**Hearing Day 3; Issue Specific Hearing; Compulsory Acquisition Hearing**

Drawing title
**WORKS PLANS
REGULATION 4 (2) (e)
SHEET 28 OF 31
WEST DRAYTON**

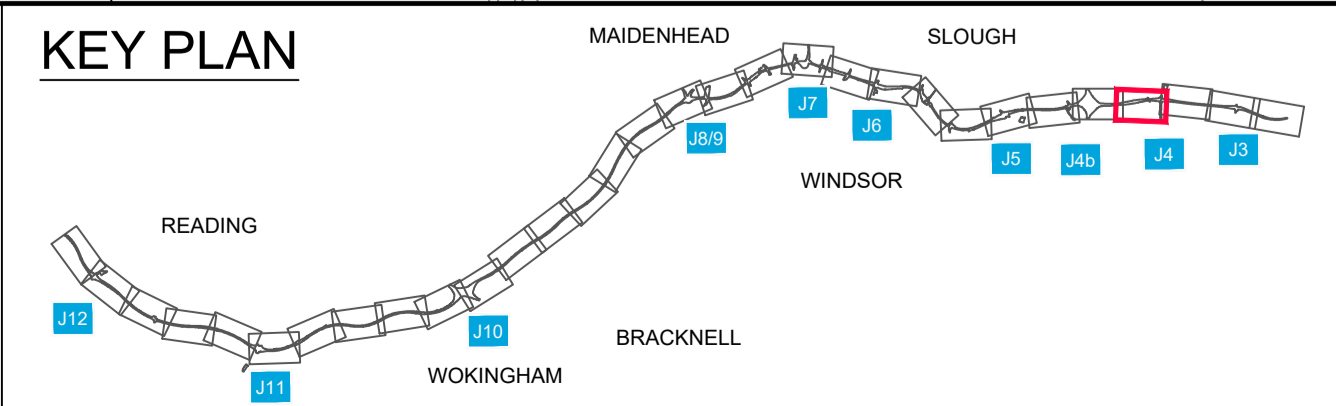
ExA Question	Written response (provided at Hearing)	Additional comments/information as requested by ExA
<b>A. PRELIMINARY MATTERS</b>		
<p>5a. London Borough of Hillingdon (LBHill) object to the need for HE to temporarily possess specific lands [plots 28-04, 28-05, 28-06, 28-07, 28-09, 28-10, 28-11 and 281-12] as it is ‘significantly more than is required for temporary access and working space for extension to Sipson Road subway’ REP2-060. Further concern is expressed in respect of public rights of way (PRoW) closures and engagement with neighbouring occupiers.</p> <p>i. Can HE respond to the objection raised by LBHill in respect of the extent and duration of TP power</p>	<p>The applicants advised at the hearing that due to the implementation of alternative construction techniques, the Sipson subway would not be closed for the duration of a year as initially stated in documentation submissions.</p> <p>The applicants confirmed that there are alternative construction techniques which they are likely to employ on the subway works, which would allow for pedestrian access to be maintained for the 1 year duration of works at the site. The applicants advised that this is possible by only having closures at weekends, evenings and over school holidays to minimise disruption. The applicants did advise that there would be the need for some closures and diversions, but this would be limited in its duration. Officers will continue to speak to the applicants to ensure that we all receive further information and assurances that the subway closures will be minimised through the measures that were discussed at yesterday's hearing.</p> <p>It was also advised that the applicants confirmed that the access from Vine Close to Sipson Road will remain open as this land is no longer required for the works.</p>	<p>The councils requests appropriate amendments to the draft CEMP to reflect the comments made with regard to the Sipson subway closure at the hearing, this should include the mechanisms by which it is possible to prevent permanent closure of the subway which the applicants propose to employ. It would appear that there is no alternative means to secure the in principle offer made by the applicants to seek to minimise the closures to the subway.</p> <p>An update of all plans is also required to reflect the reduction of the temporary CPO lands which will allow access from Vine Close to Sipson Road.</p>
